# City of Albuquerque Stormwater Construction Site Inspection Report

ESC File No.	M15E054	Project Name:	Veterans Integration Center		
NPDES Id. No.	NMR1005M1	Location:	2701 Mulberry St. SE		
5/15/2023	Owner	Contractor			
Operator	NM Vertran Integration Centers		Jaynes		
Contact name & title	Jerry Becker				
e-mail	<a href="mailto:jerry@steamaticnm.com">jerry@steamaticnm.com</a>				
Contact Phone #	505-833-7766				
COA Inspector	Doug Hughes		Start/End Time:	4:30pm	
Construction Phase:	Apartment Bldg complete, north lot dirt.				
Type of Inspection:	<input type="checkbox"/> Regular	<input type="checkbox"/> Storm Event	<input type="checkbox"/> Past Storm Event >0.25"	<input type="checkbox"/> 311/Complaint	<input checked="" type="checkbox"/> Follow Up
Weather at time of inspection?		clear		Temperature:	~ 80
Estimated date of last storm 0.25" or greater		3/16/2023

ESC-1

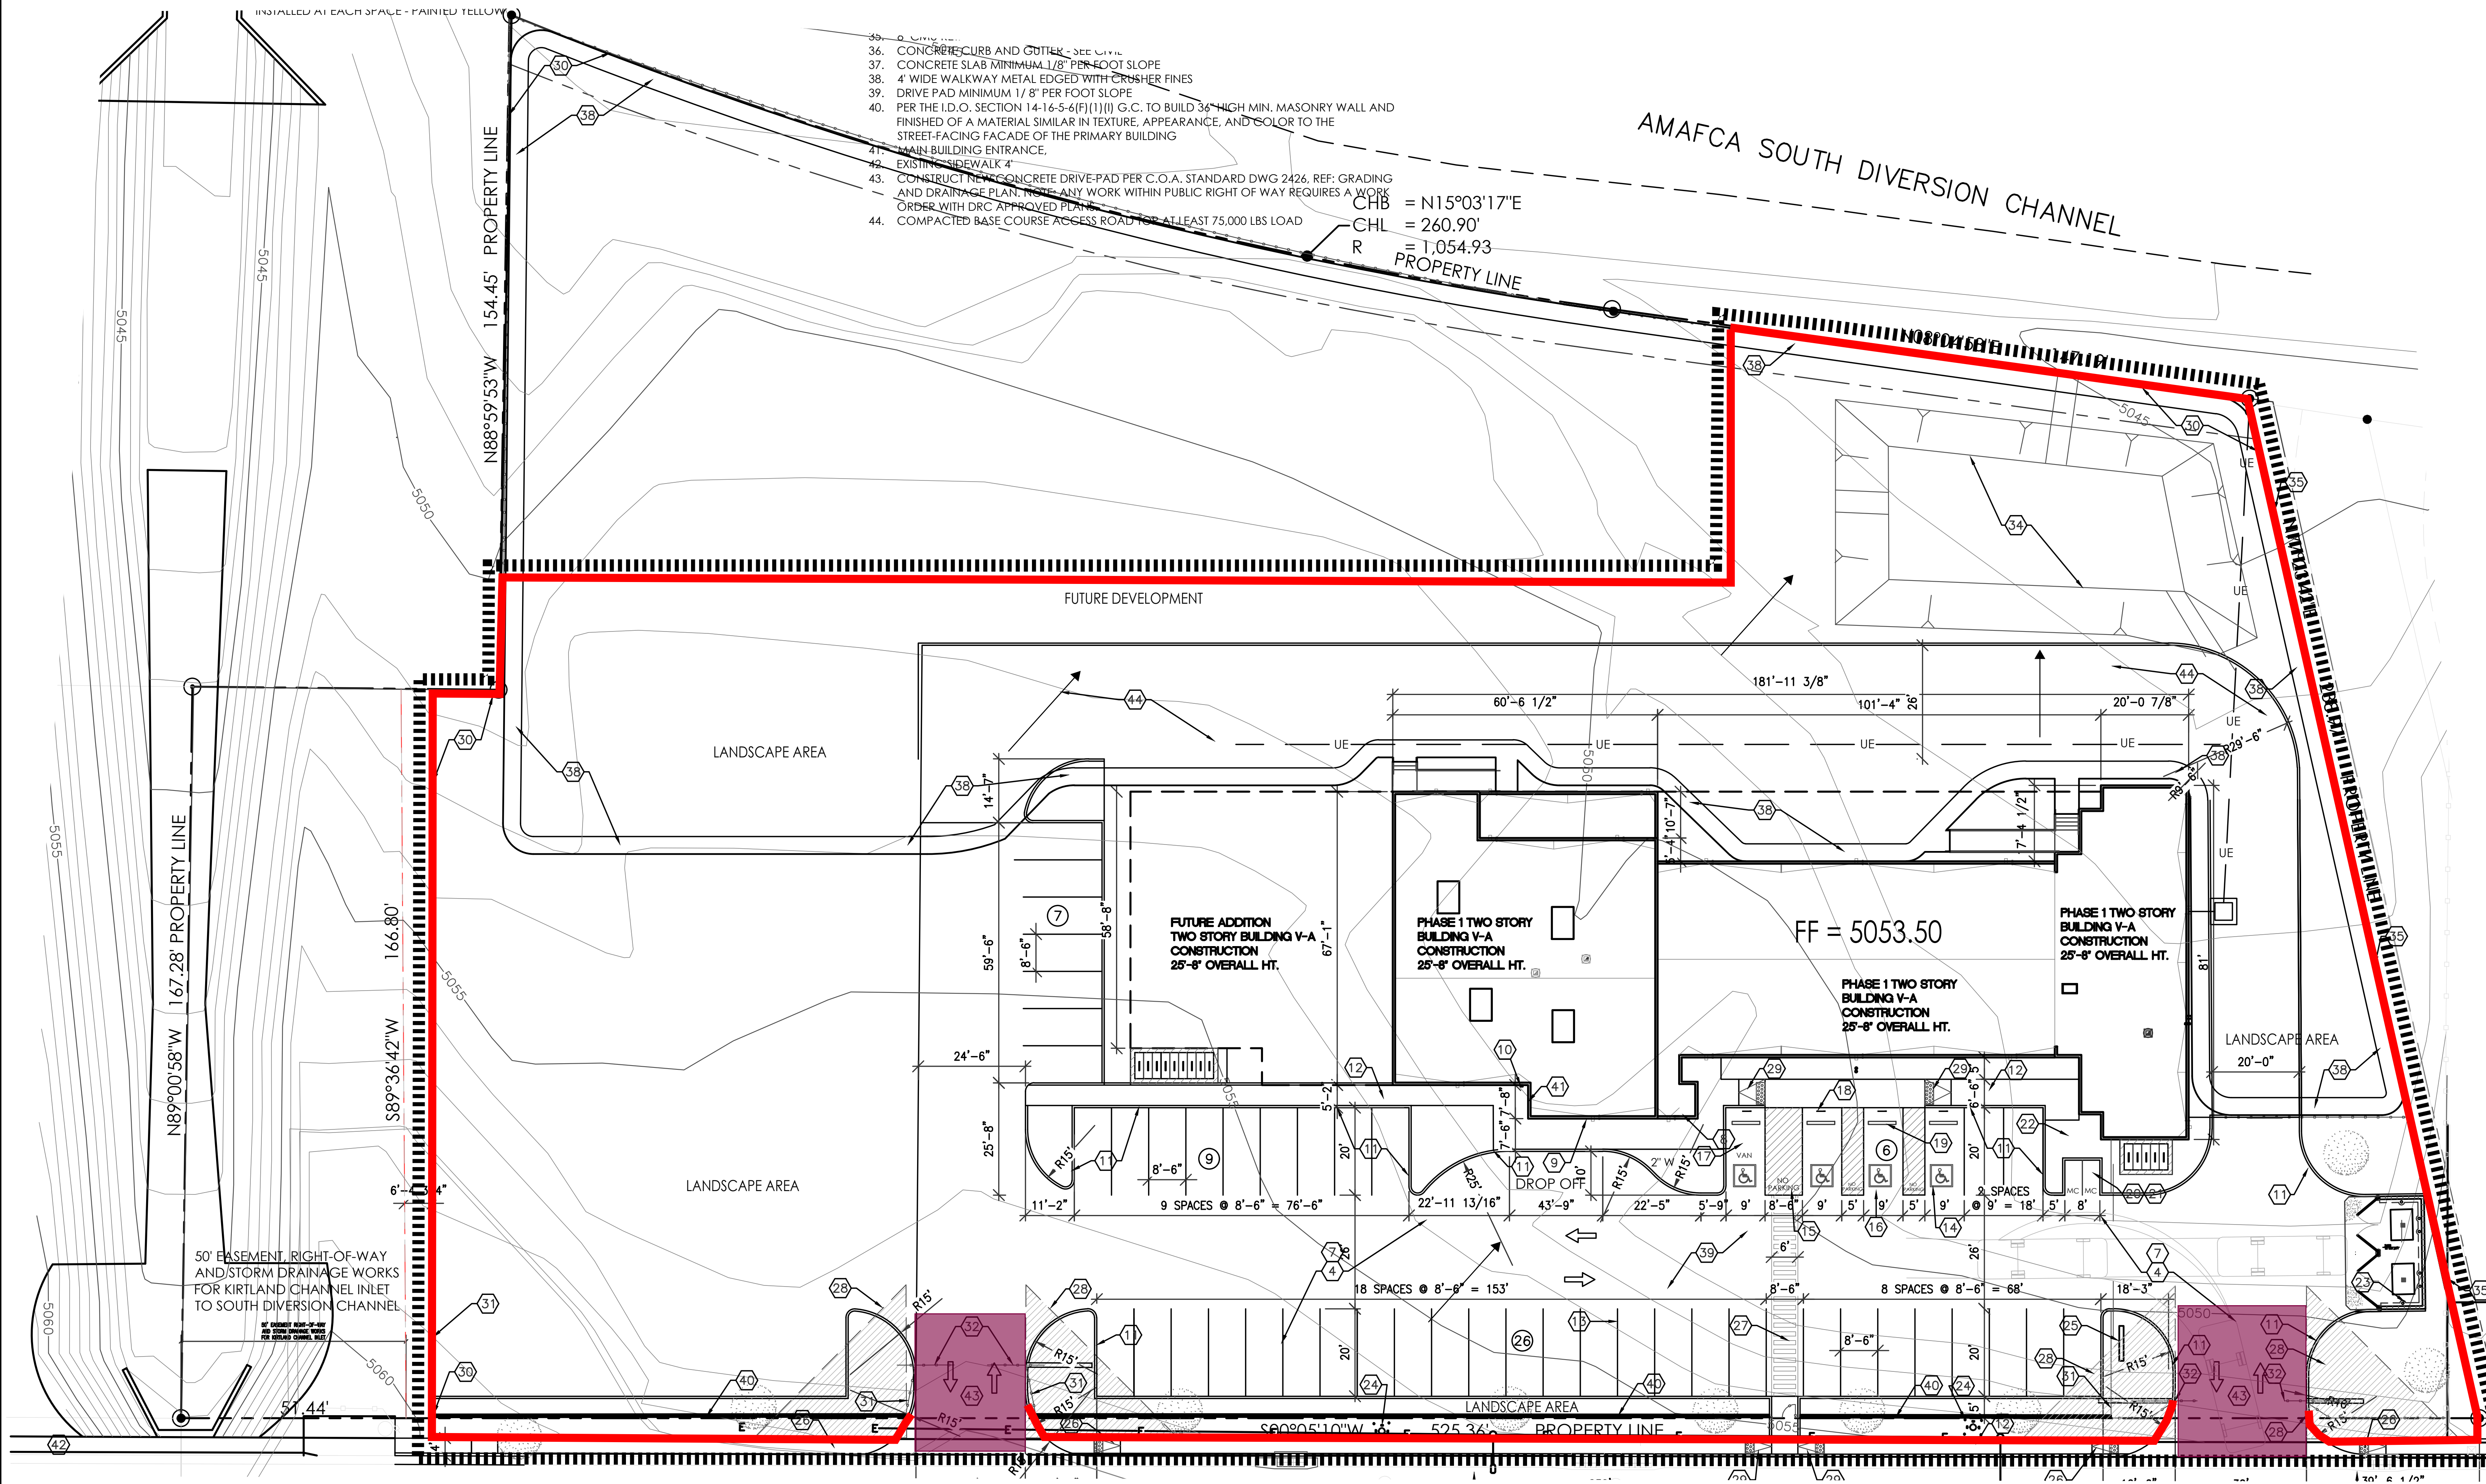
Item Number	Deficiency/ Corrective Action
1	BMPs were completely missing from the site and sediment from your site has blown into Mulberry St. Your BMPs (silt Fence) must be constructed, and sediment picked up and removed from street.
2	SWPPP not available on site at time of inspection, so it couldn't be checked to see if it is up-to-date. 6. The SWPPP including Self Inspection Reports and Corrective Action Reports must be kept up-to-date per CGP 7.1 and available on-site per CGP 4.7.3, 5.4.3 and 7.3. If an on-site location is unavailable to keep the SWPPP when no personnel are present, notice of the plan's location must be posted near the main entrance of your construction site CGP 7.3.
3	Stabilization was missing - You must begin appying seed and hydromulch within 14 days no any area where construction activities cease for 14 days or more, and you must complete the seed and mulch in 14 days or less per CGP 2.2.14. You must continue permit coverage, self-inspections, SWPPP and BMP maintenance until the City determines that the Final Stabilization Criteria CGP2.2.14.c has been satisfied.
